City of Albuquerque

October 10, 2001

RE: 1029 MONTANO NW OFFICE DEVELOPMENT (F14-D50). GRADING & DRAINAGE PLAN FOR SITE DEVELOPMENT PLAN FOR BUILDING PERMIT, AND FOR BUILDING PERMIT AND SO#19 PERMIT APPROVALS. ENGINEER'S STAMP DATED OCTOBER 5, 2001.

GRADING & DRAINAGE PLAN

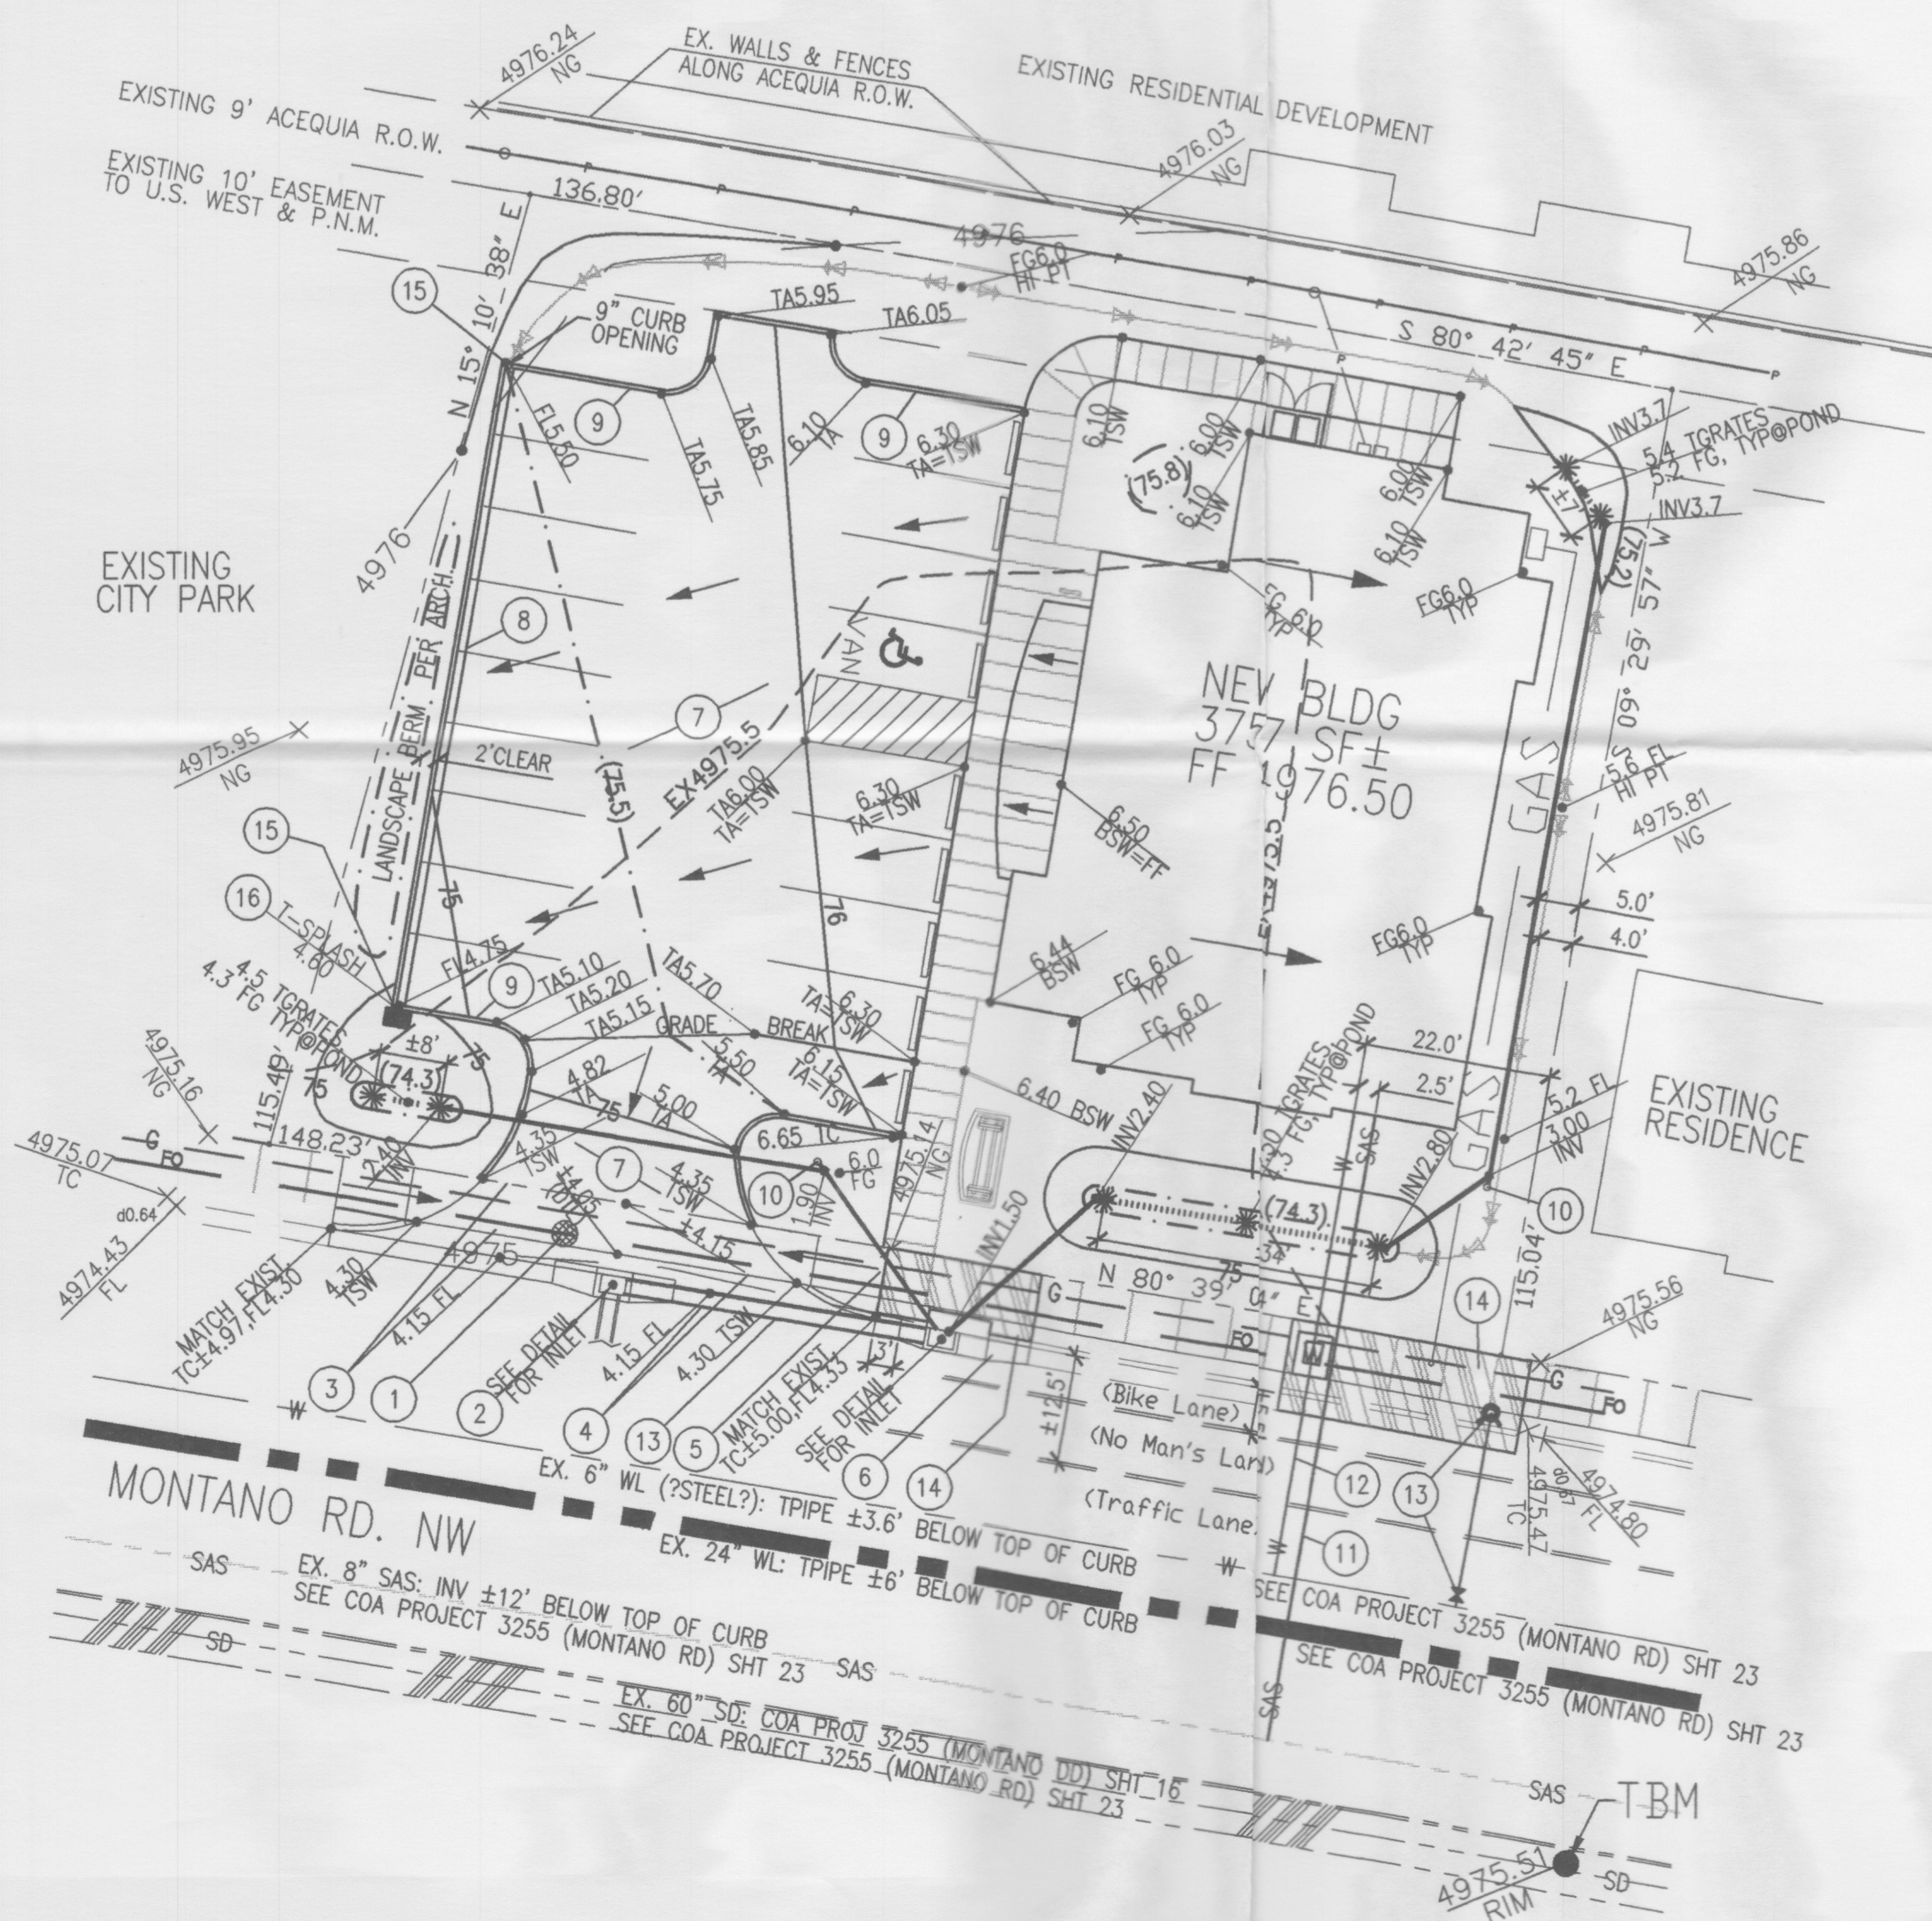
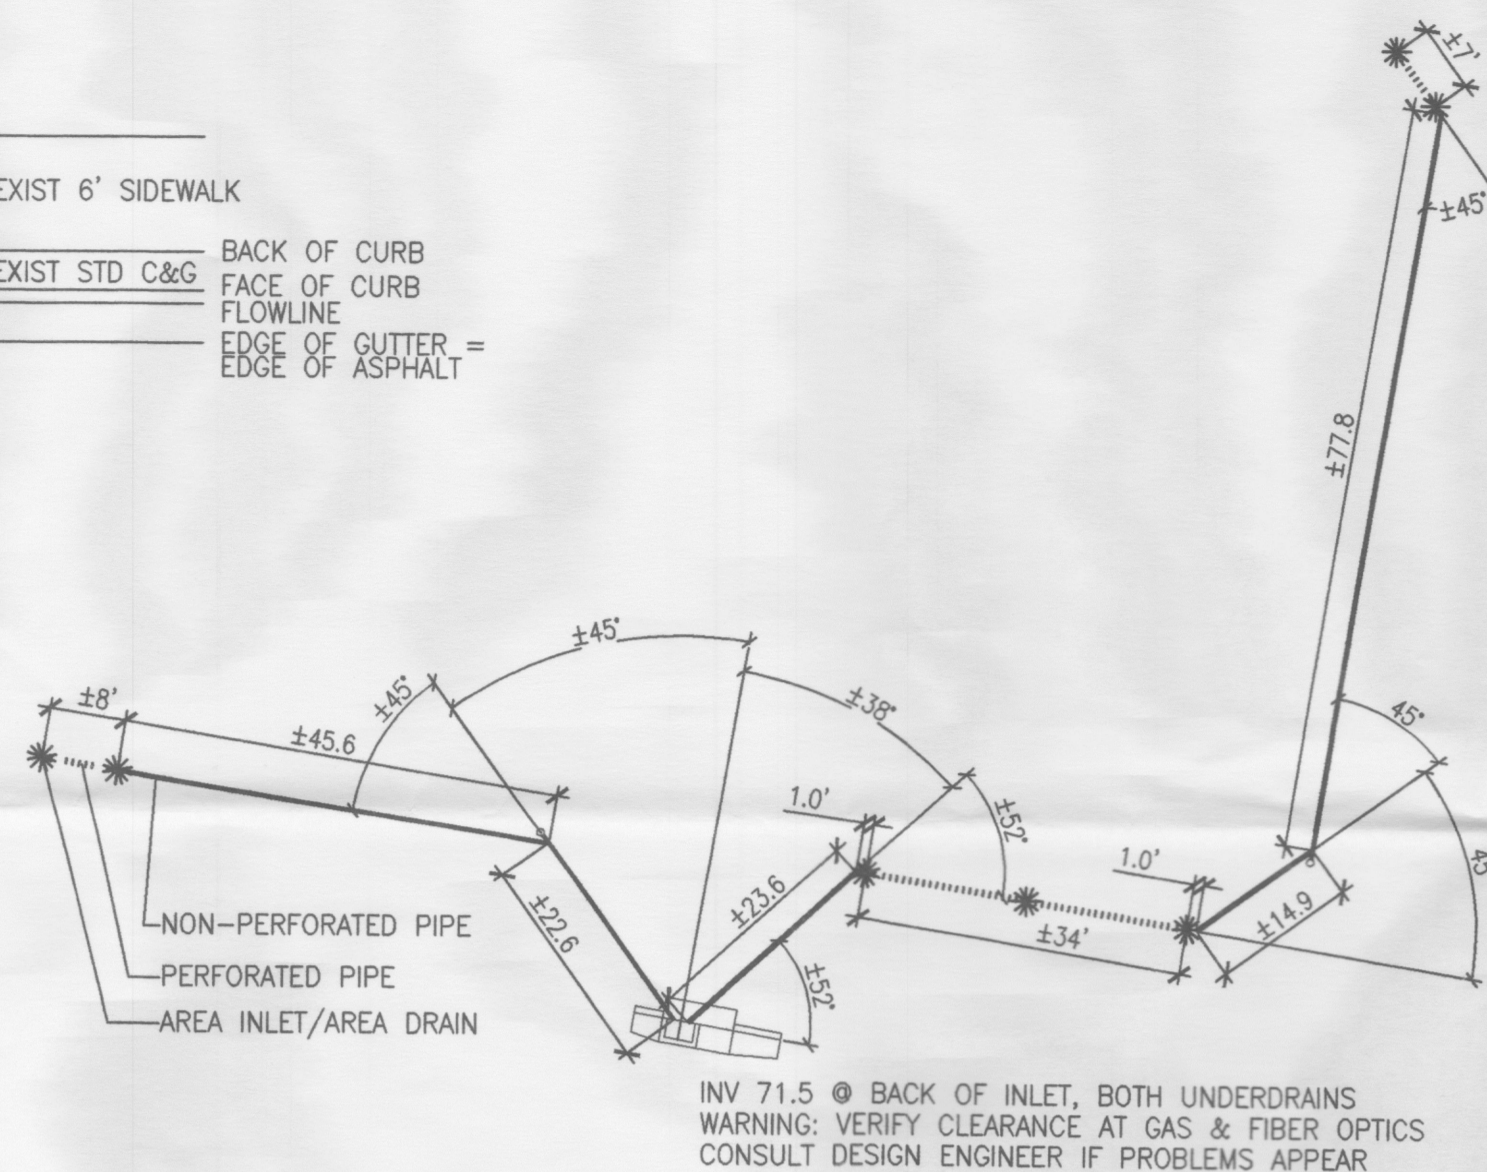
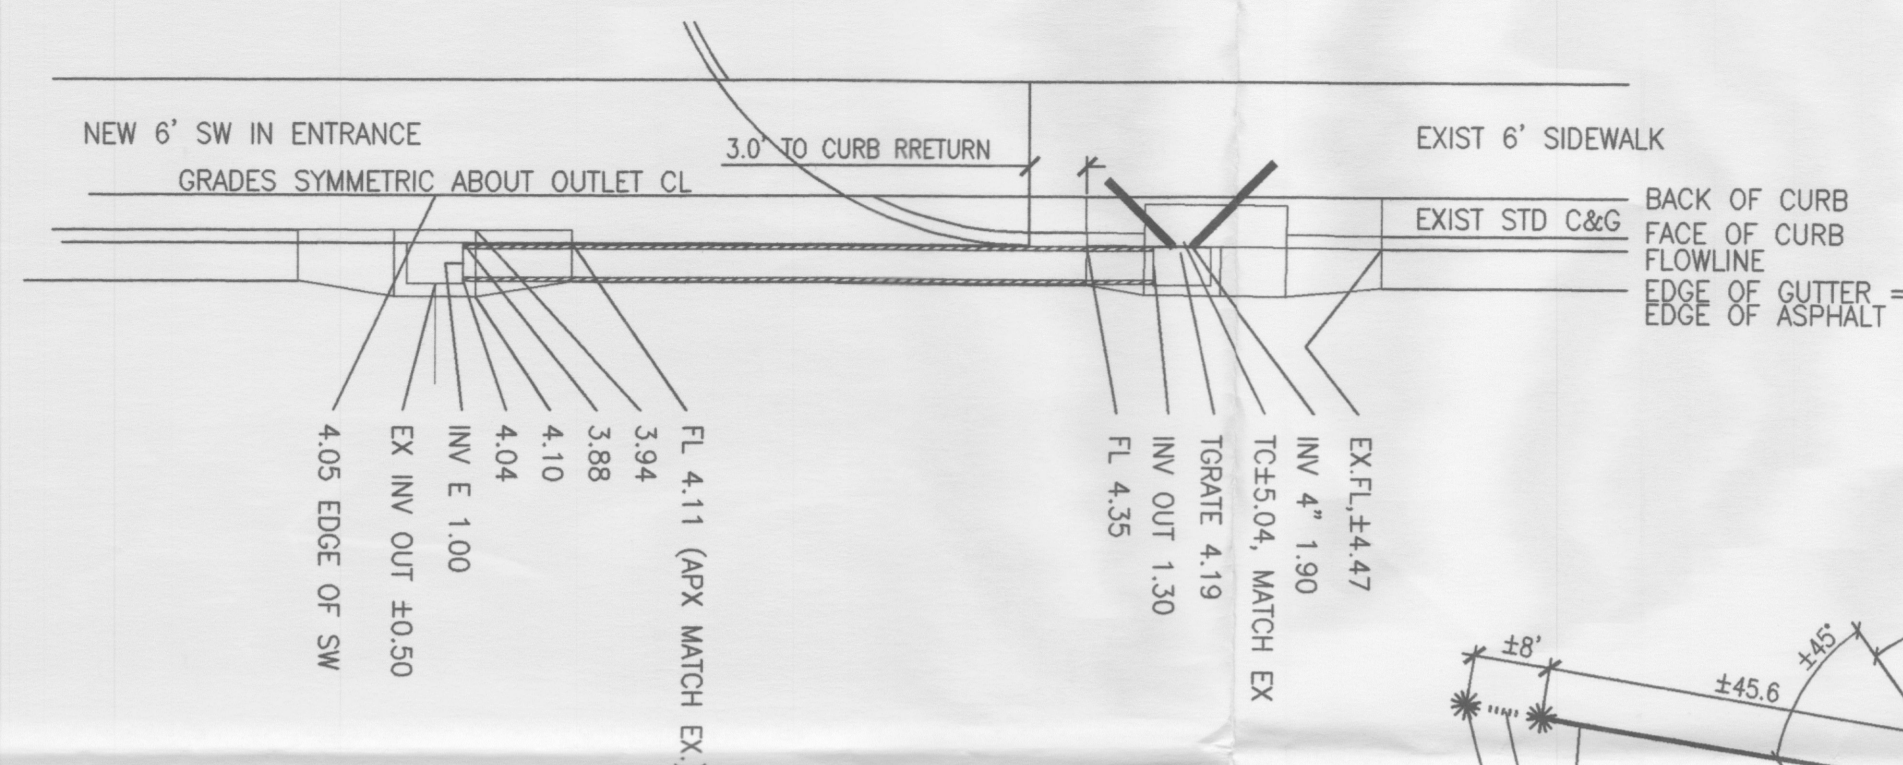
The Standard SO#19 Notes need to be added to the plan. Note that only the Inspector's Signature is now required for the SO#19.
